Consultation Response from: KC Environmental Health (Pollution & Noise Control)		
2025/90325 adj 33a Church Lane, Clayton West, Huddersfield, HD8 9LY		
Discharge of details reserved by conditions 6 (boundary treatments), 8 (intrusive site investigations and remedial works), 9 (declaration), 10 (Phase I Desk study Report), 11 (Phase II Intrusive Site Investigation Report), 12 (Remediation Strategy), 13 (Remediation Strategy), 14 (Verification Report) and 15 (Arboricultural Method Statement and Tree Protection Plan) of previous permission 2024/93464 for variation condition 2 (plans) on previous permission 2023/91483 for demolition of garage and erection of detached dwelling.		
Responding Date: 16 th June2025	Responding Officer: SR	Responding Ref: WK202517220
<u>Comments</u> In our last response dated the 27th of March 2025 we accepted the Phase I Desk Study Site Investigation Report by Geoinvestigate (November 2024, G24327) and recommend that Condition 10 is discharged. We also accepted the Phase 2 Intrusive Site Investigation Report (December 2024, G24327) and Gas Monitoring Addendum Report (March 2025, G24327) both by Geoinvestigate and recommend that Condition 11 is discharged. Th

Remediation Plan

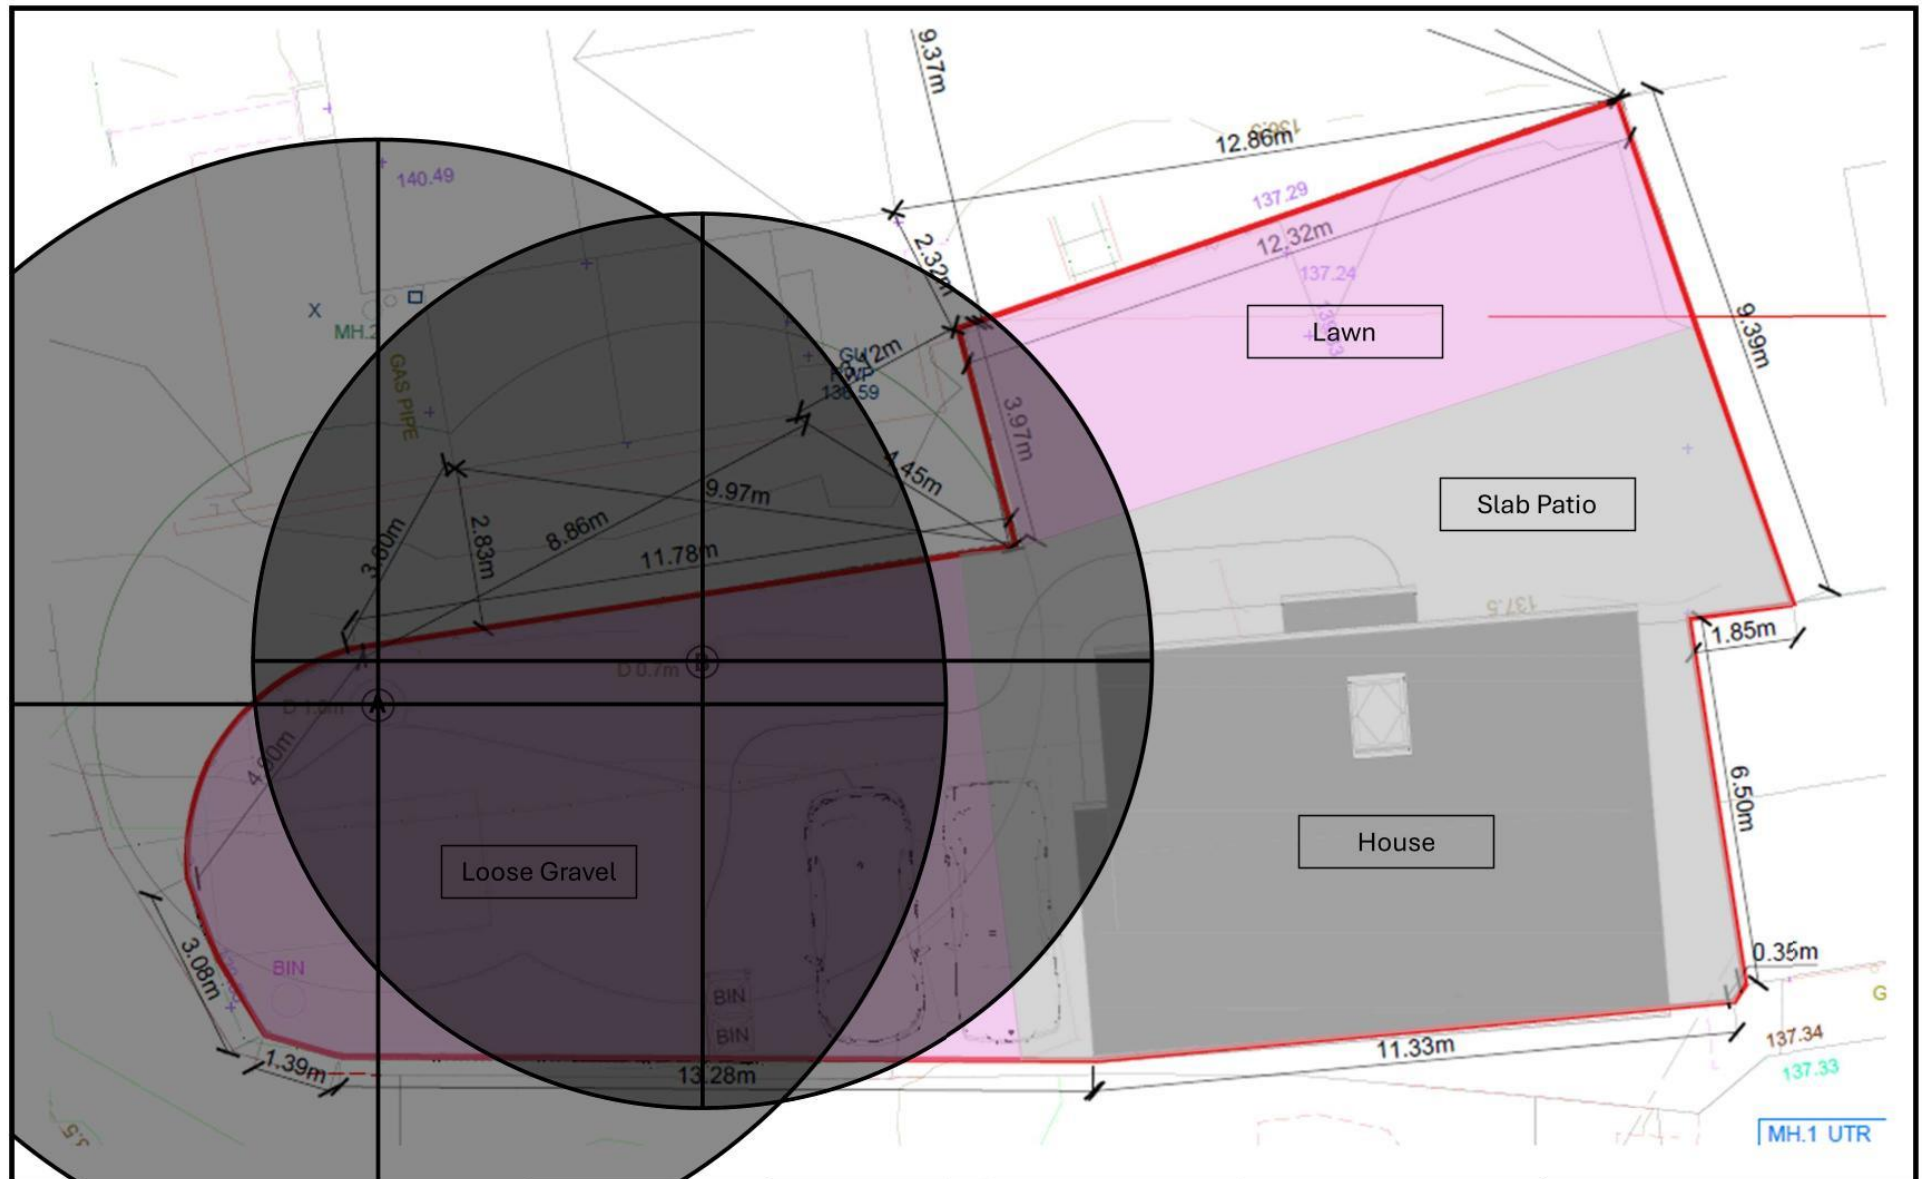
We do not accept the Remediation Strategy Report by Geoinvestgate, dated April 2025, ref: G24327, the 300mm clean cover depth in soft landscaped areas may be insufficient to ensure there is adequate protection for end-users. We therefore request that the contaminated land consultant provide further information to address these concerns.

Additional risk assessment, GI or revised proposals may be necessary. This must be undertaken by a competent person as defined in the NPPF. Any new information must confirm, to a high degree of confidence, that the remediation strategy will ensure adequate protection for end users

For the reason stated above we do not accept the Remediation Strategy Report by Geoinvestgate, dated April 2025, ref: G24327, condition 12 must therefore remain.
